Booker Hall, Oakhurst Gardens, Littlehampton
Structural Engineer's Feasibility Study

May 2021

EngineersHRW have been appointed by Littlehampton & Rustington Housing Society to provide a preliminary structural engineering appraisal of architectural proposals by Studio Scott Taylor for the site at Oakhurst Gardens, Rustington, Littlehampton. The project comprises the demolition of an existing resident's hall at Rustington Hall Care Home and construction of a replacement facility that will better meet the needs of the residents. Our current appointment covers a desktop study of site conditions and constraints and preliminary advice on the structural design of the scheme to support the planning application.

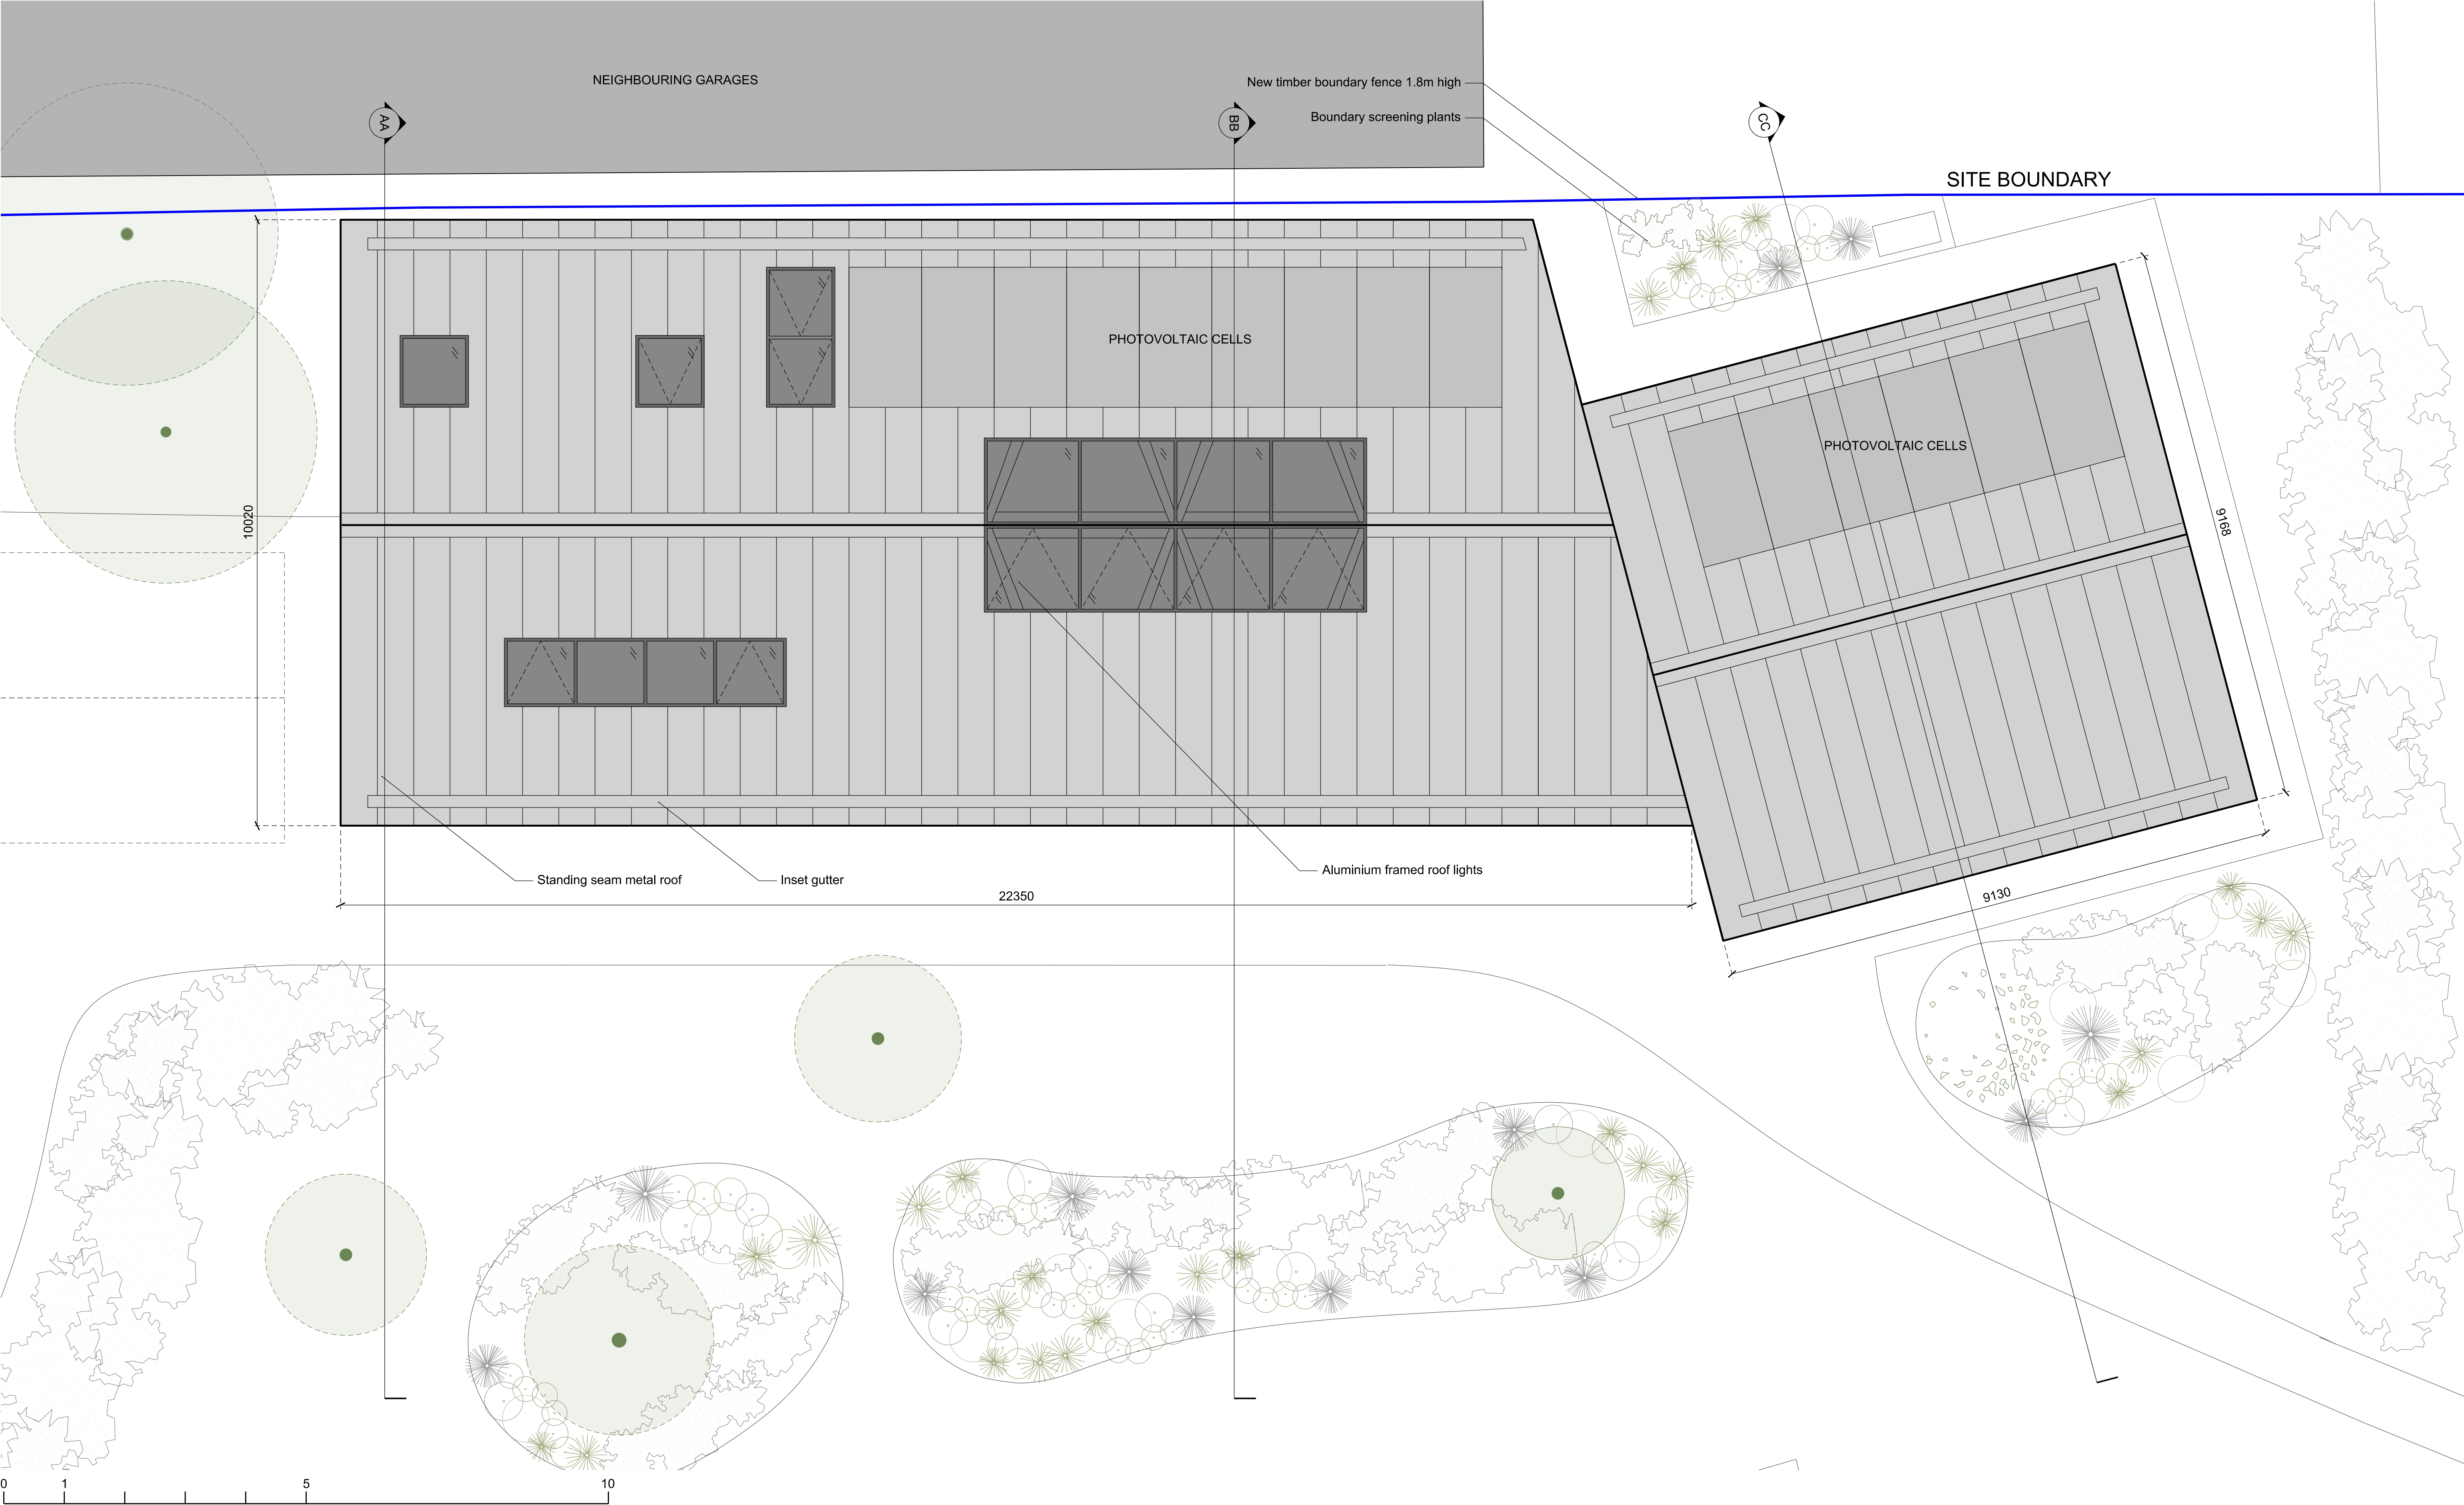
The structural proposal for the hall roof is to form a deep truss in the roof plane either side of the ridge. Glulam rafters zig-zag across the length of the hall to provide out-of-plane stiffness and act as the

bracing of the deep truss. Glulam ridge and eaves elements form continuous lines of compression and tension respectively to distribute lateral loads to gable ties and stability walls, as the pitched roof tends towards flattening at the ridge and pushing the eaves in an outward direction. Refer to the plan mark-up in Appendix A.2 (SK02).

Glulam roof frame elements over all checked as 140 x 280mm GL24h, subject to confirmation of roof loadings and design development. This size applies to rafters, eaves and ridge beams, and columns. It is assumed that all elements are aligned with coincident centrelines.

Eaves ties continuous over recessed bay at ground floor level.

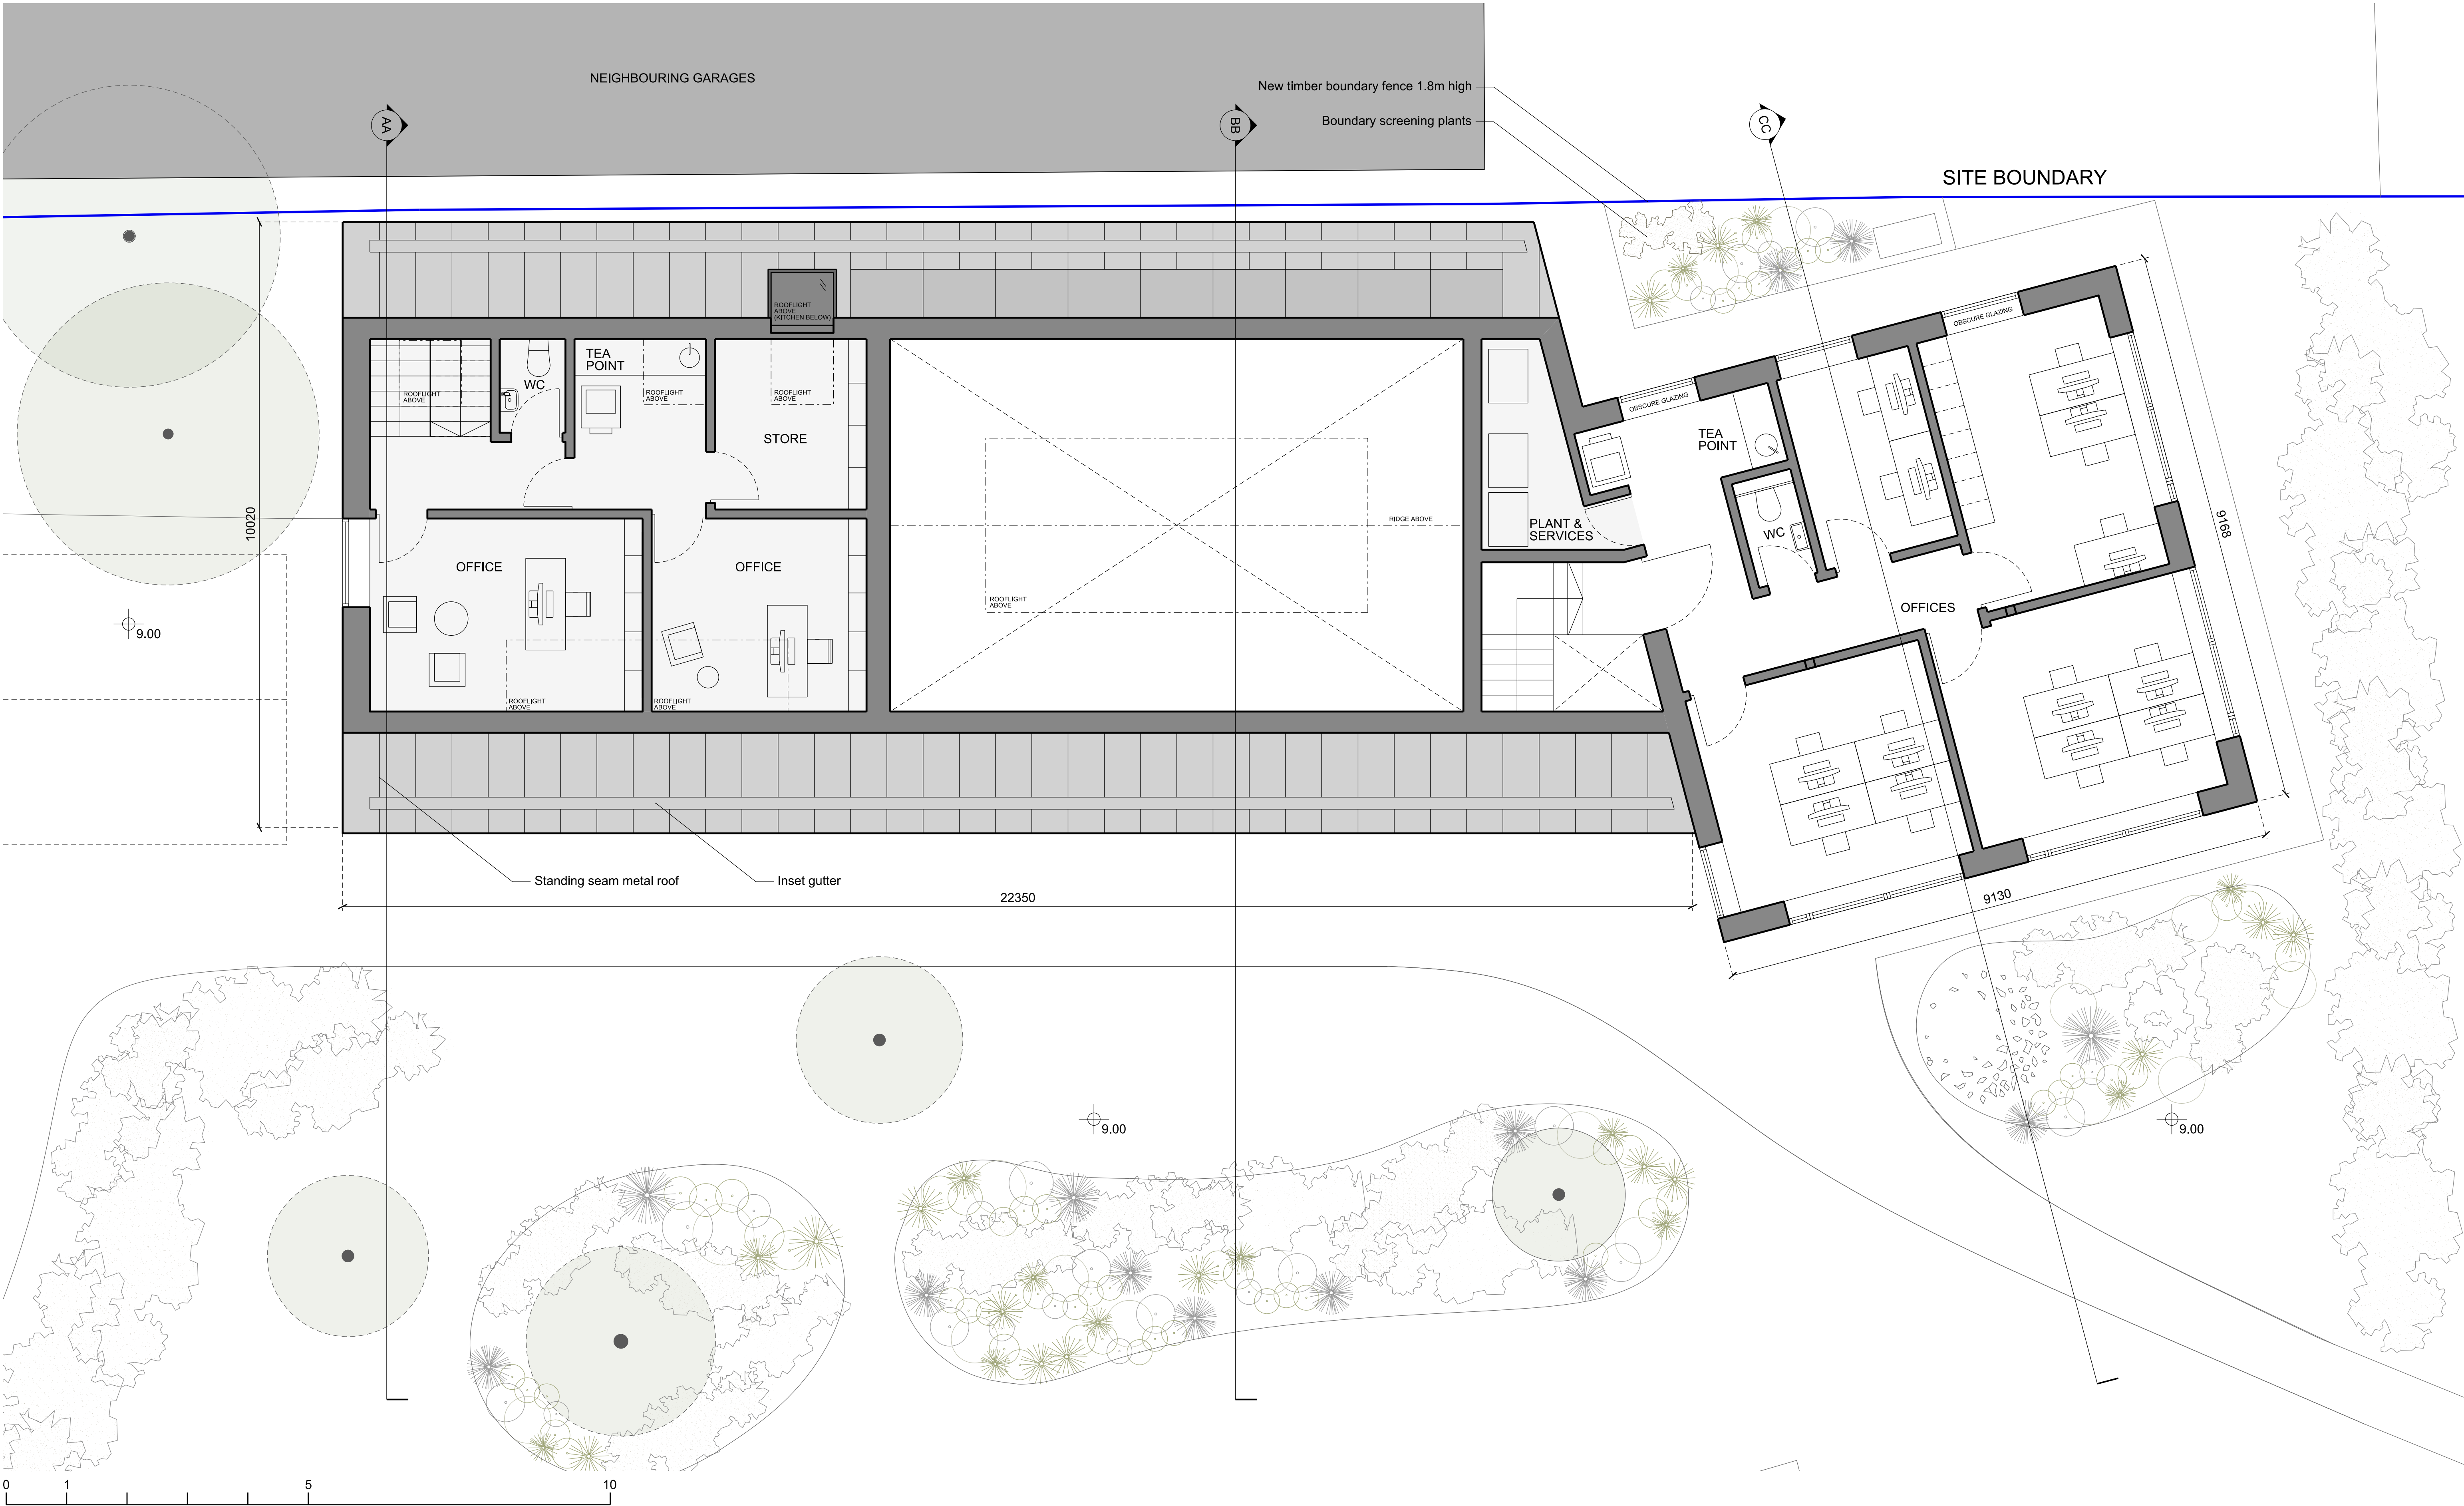
Office variation with internal load-bearing columns and transfer beams supporting the first floor CLT deck. Refer to SK01 for further options and roof proposals considered at this stage.

Gable level tie beams continuous between corner columns on either end of the hall with shear walls beneath. It would be preferable structurally to move the position of this door to get one longer length of wall along this line.
